Consultation response from KC PROW (footpaths)

2023/91212 Land off Bankfield Drive, Holmebridge

Erection of 16 dwellings with access from Laithe Avenue

Date Responded : 16/5/23

Date:	21.01.21	Project:	Bankfield Drive, Holmebridge
Scale @ A3:	1:500	Drawing Number:	2021.01.003
Drawn By:	CD	Revision:	V

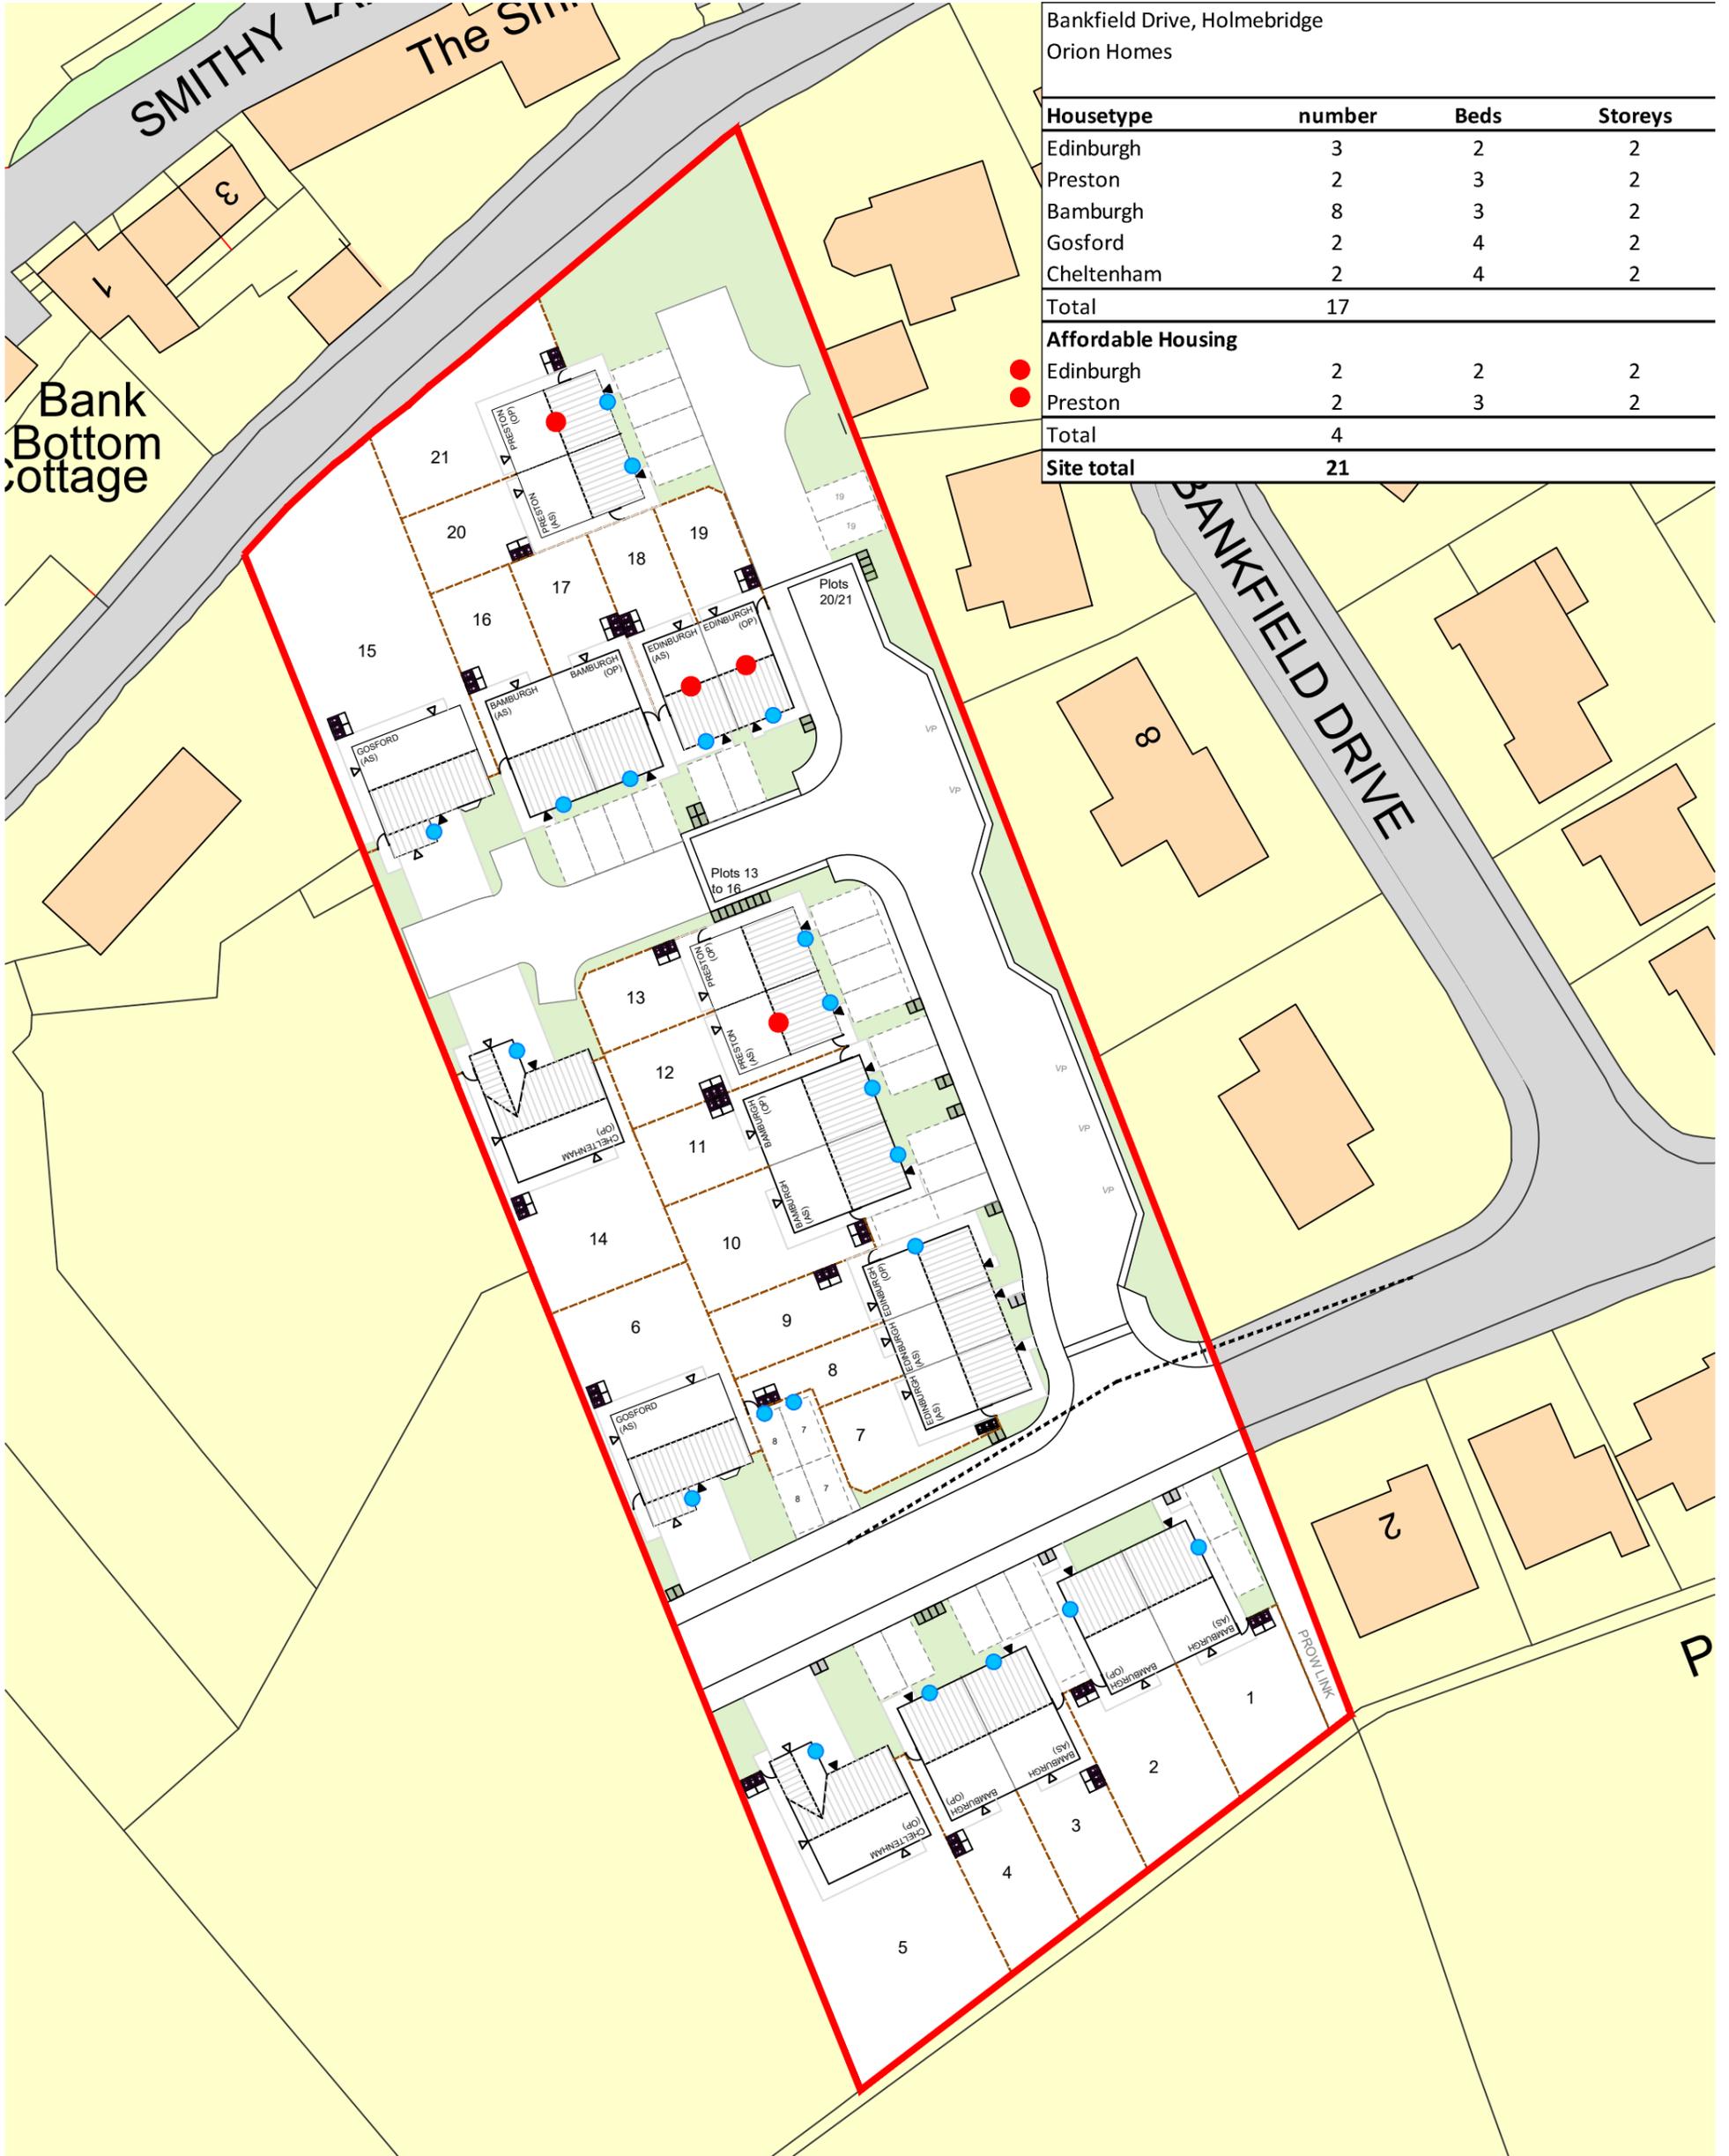
Prow welcomes the new footpath to the definitive footpath at the rear of the development, and are pleased that this is shown as a 2.5 metre width. This link will provide a good connection to the existing prow network. We would look for this link to be secured as part of any adoption of the development.
